Recommendation Report for Planning Permission for Works or Extension to a Dwelling

REF NO: AW/335/19/HH

LOCATION: 18 Gunwin Court
Aldwick
PO21 4BW

PROPOSAL: Single storey rear extension and construction of larger garage.

Drawing title **Proposed Floor Plans**

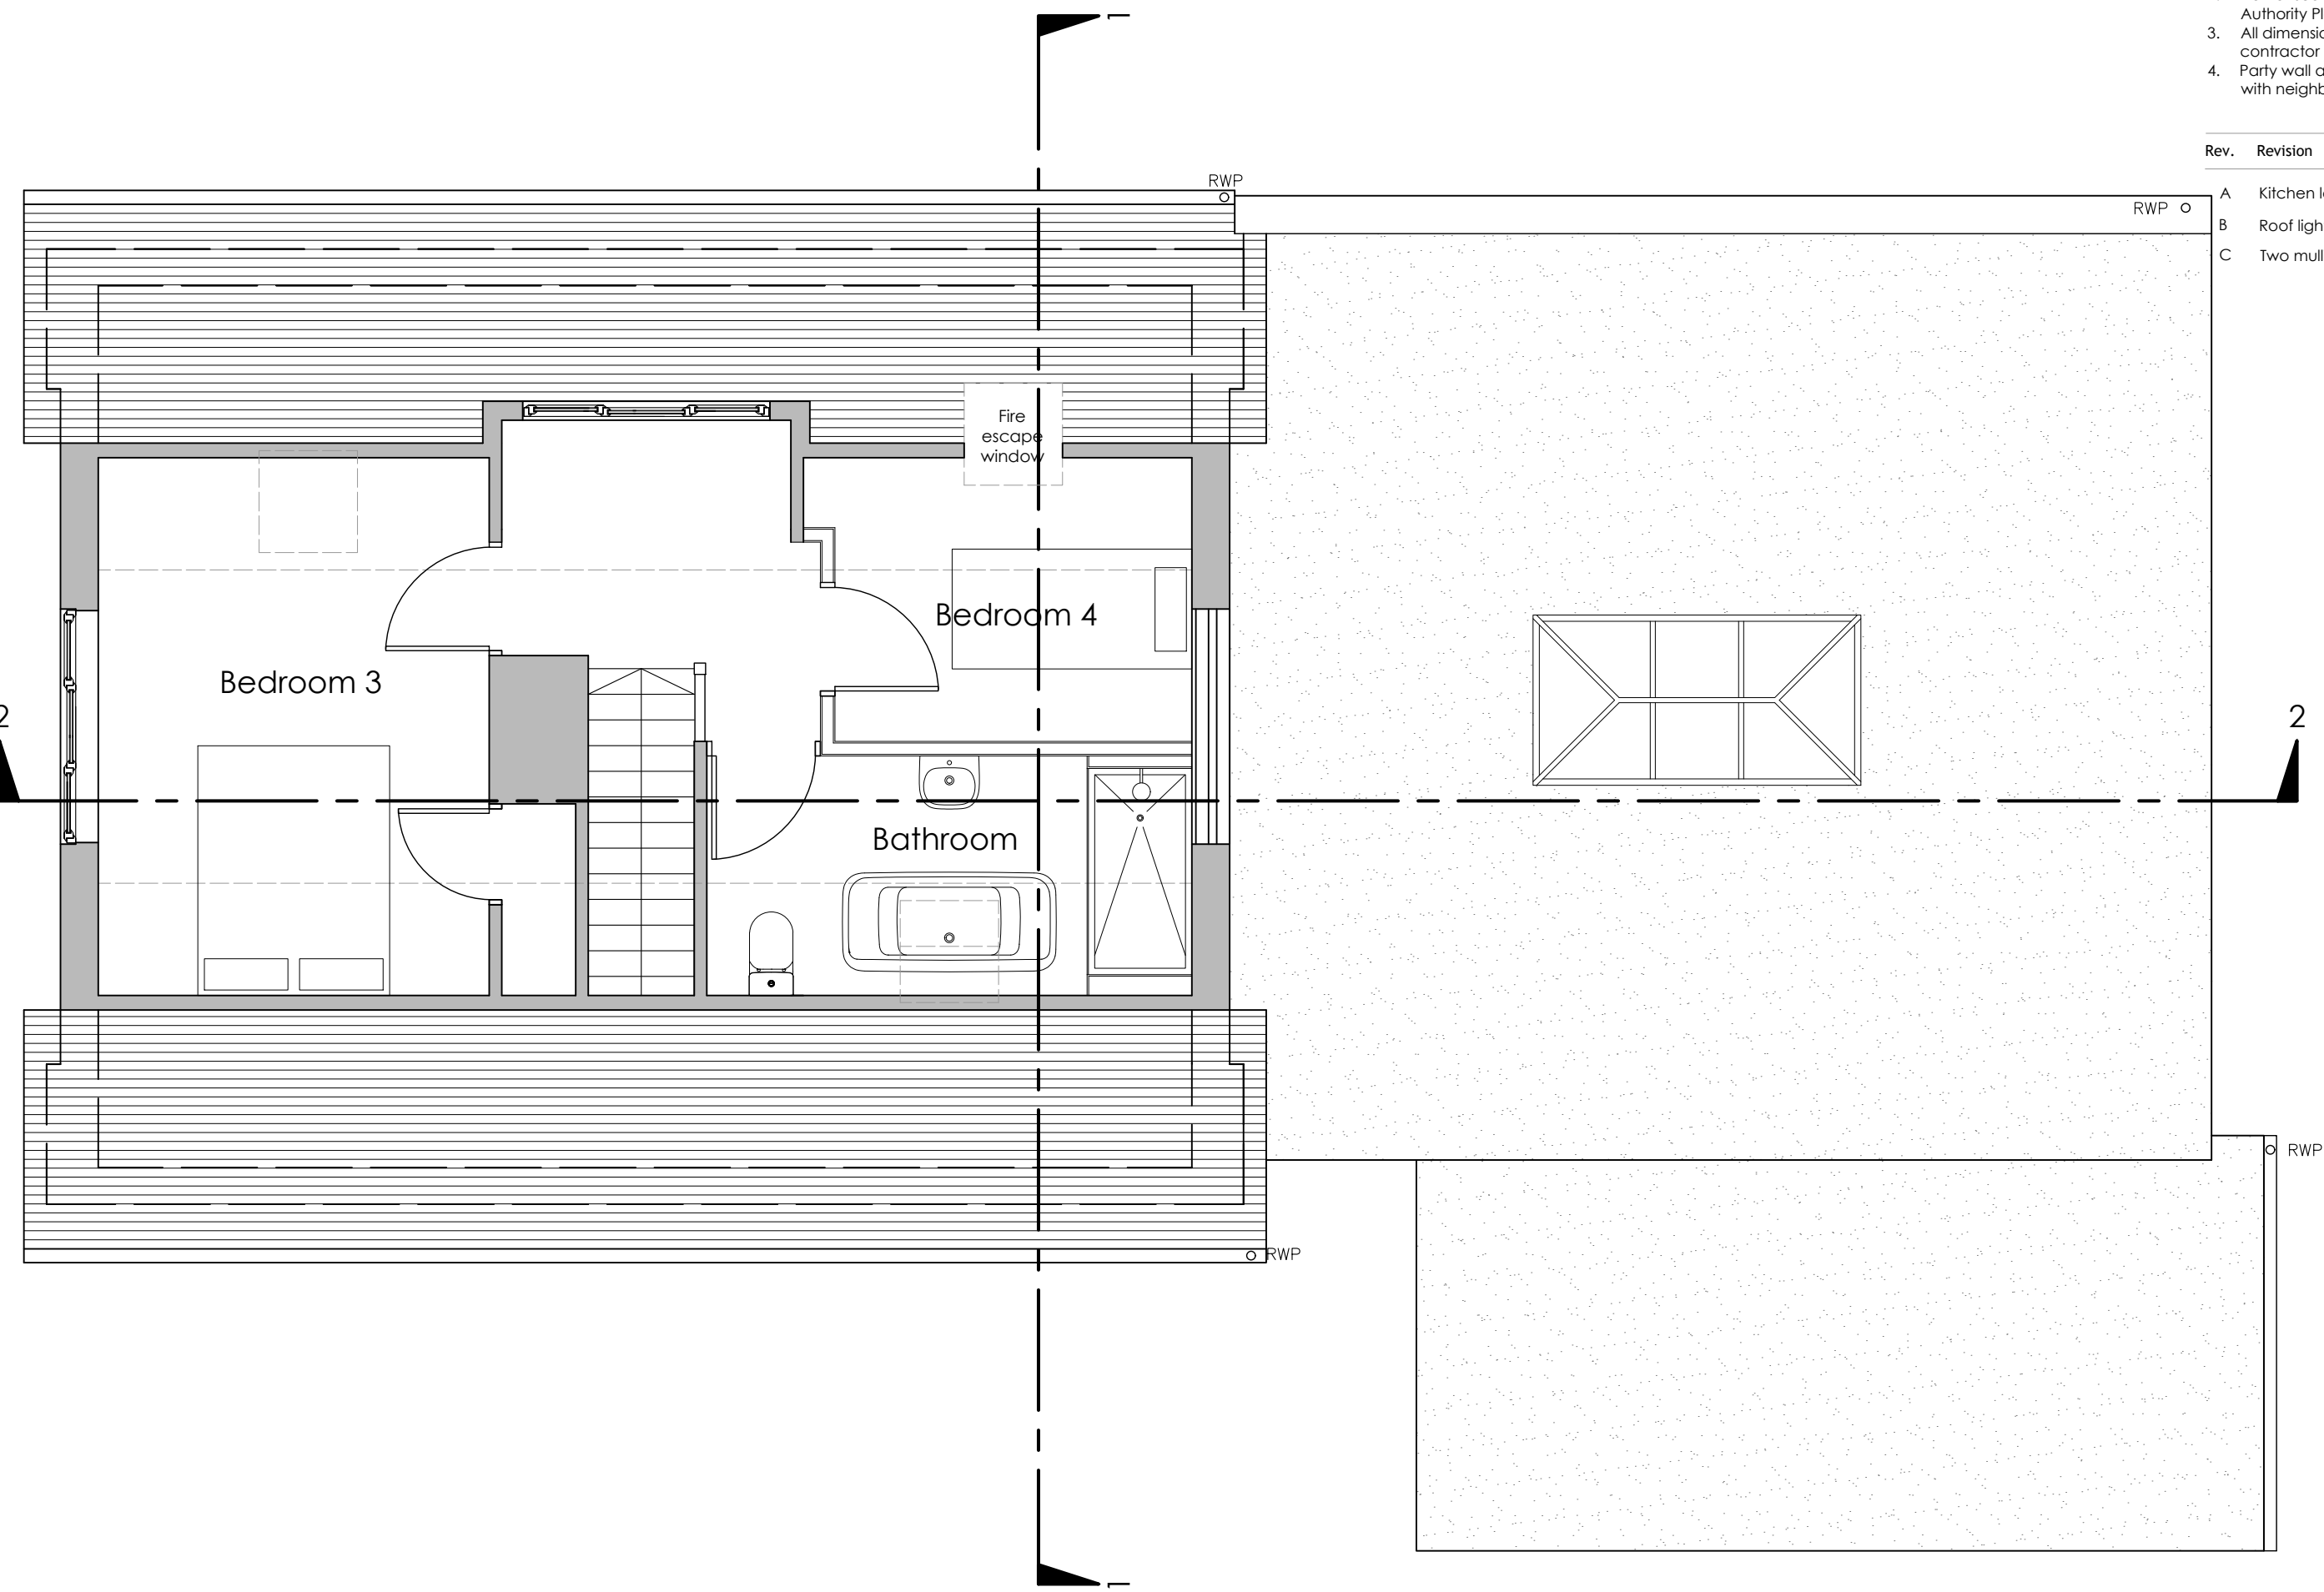
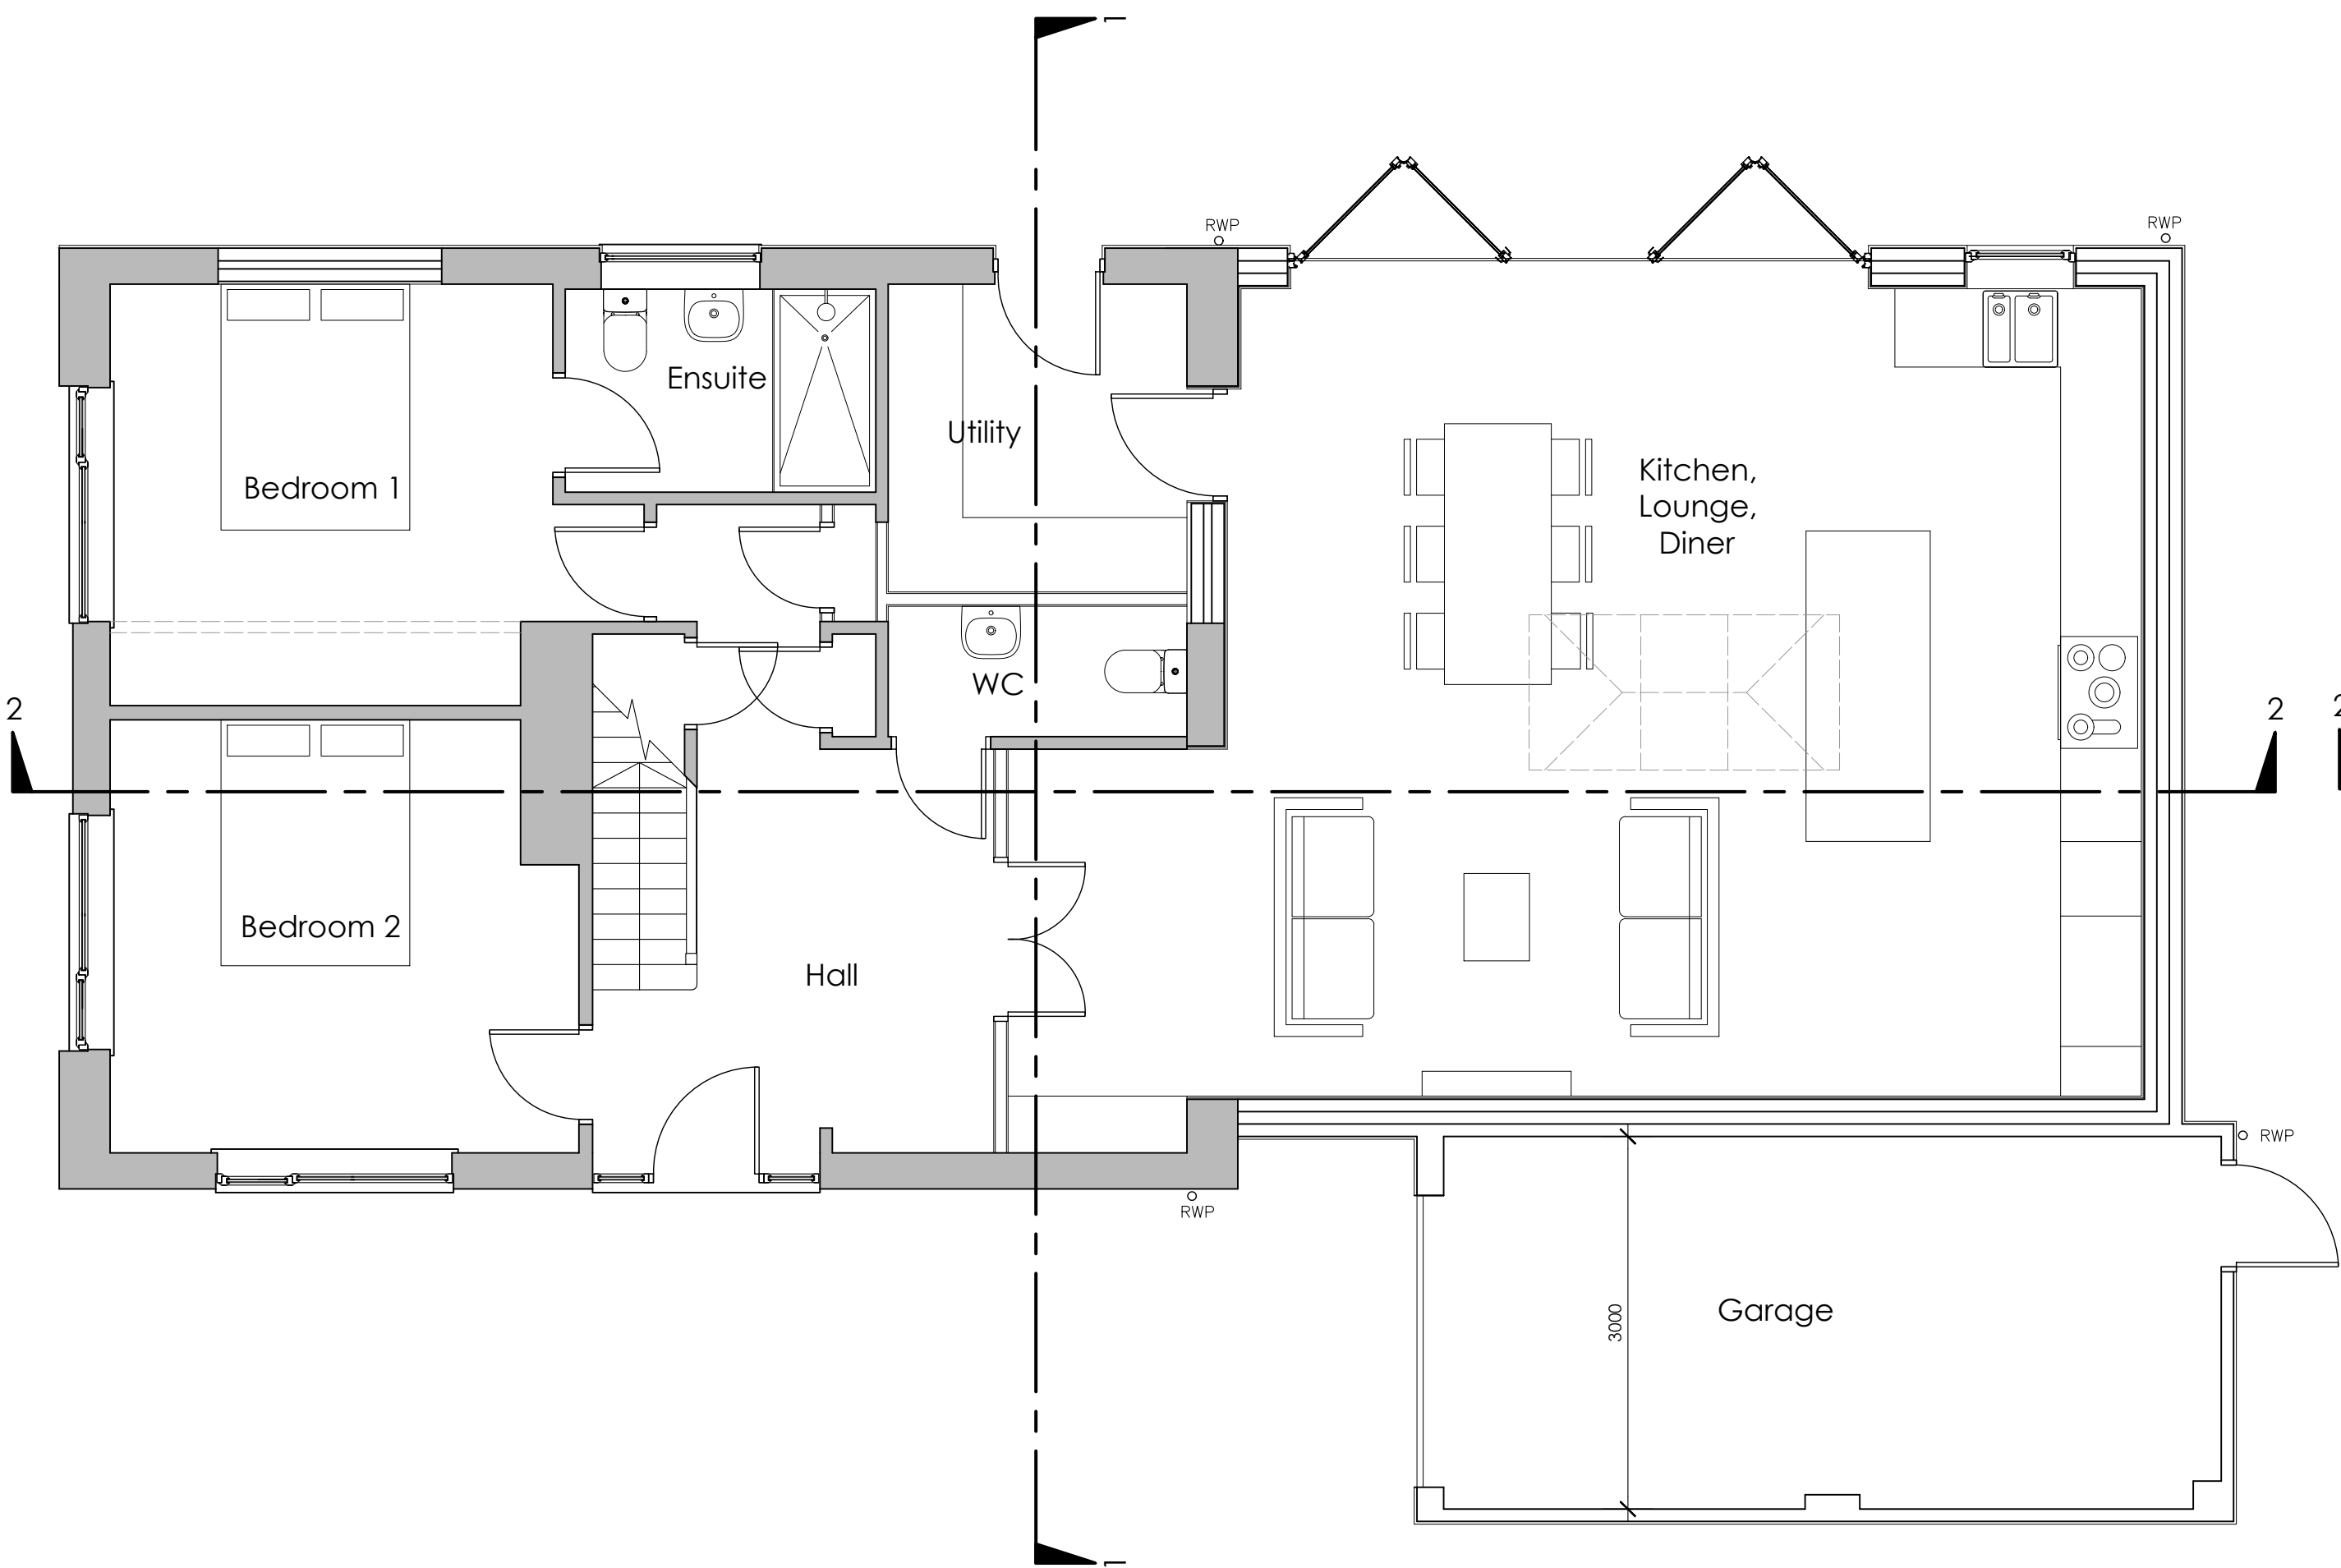
The proposal will extend from the north west rear elevation with a depth of 7.65m and run the full width of the property. It will have flat roof with a height of approximately 3.15m and 3.5m with roof lantern.

There is an existing garage which will be slightly enlarged with its depth increasing around 1m to 6.7m towards the front elevation of the property. The height will increase around 0.1m to 2.4m. The garage will remain largely the same as existing and runs along the boundary to the north west. The garage attaches to the proposed extension.
